**draft subdivision plat review**

Mon, Jul 11, 2016 at 10:36 AM

**Ocean Ave No 23 Site Subdivision Plat 6 07 2016 Survey Review 7 11 2016.PDF**

SITE/SUBDIVISION PLAN (PRELIMINARY) OF 23 OCEAN AVENUE PORTLAND, MAINE
FOR RECORD OWNERS: STEVEN E. AND ROBERTA S. COPE
FOUR POINTS ASSOCIATES, INC.
Donald E. Dostie PLS, Principal
9 Ralph Avenue, Lewiston, ME 04240 Tel. 207-577-5840

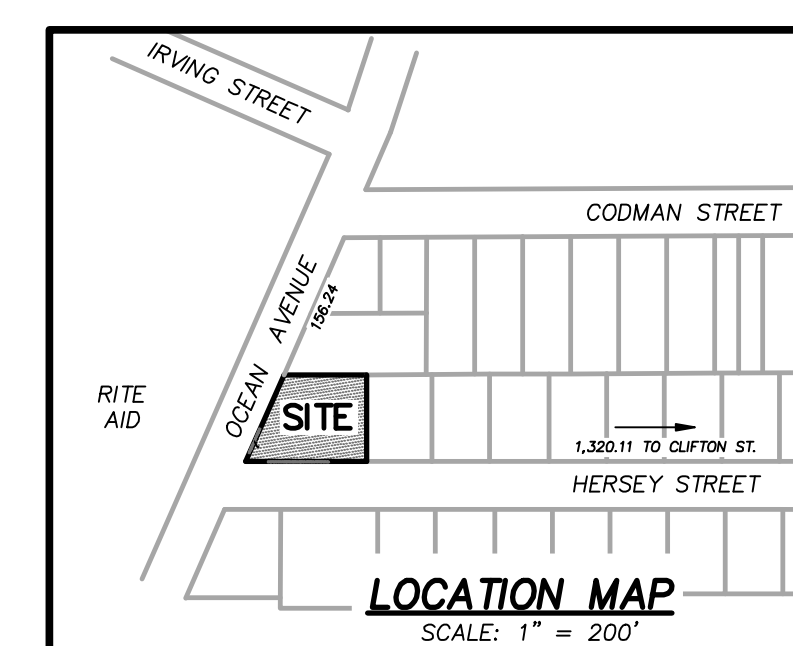
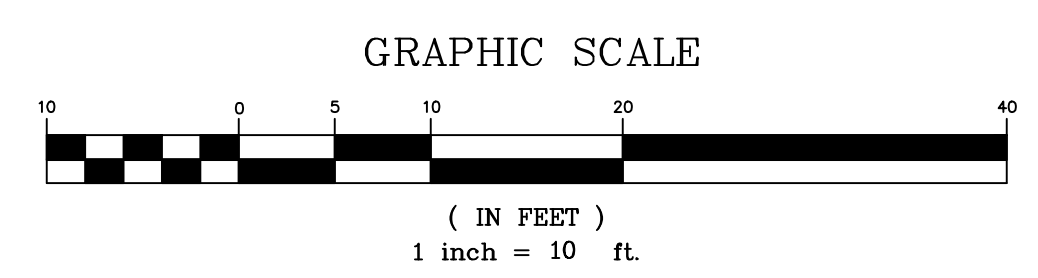
1. The sidewalk at corner of Ocean Ave and Hersey St shows as being constructed on the private property. Currently the sidewalk is within the City street ROW limits for Ocean Ave and Hersey St. If it is expanded onto the private property the City will need a public easement for that area and a detail on the plan showing bearings, distances, and curve data for the easement metes and bounds description.
2. The proposed aerial licences in Ocean Ave and Hersey St will need bearings, distances, and curve data added to the plan for the license metes and bounds descriptions. The vertical clearance in the license areas will also need to be stated.
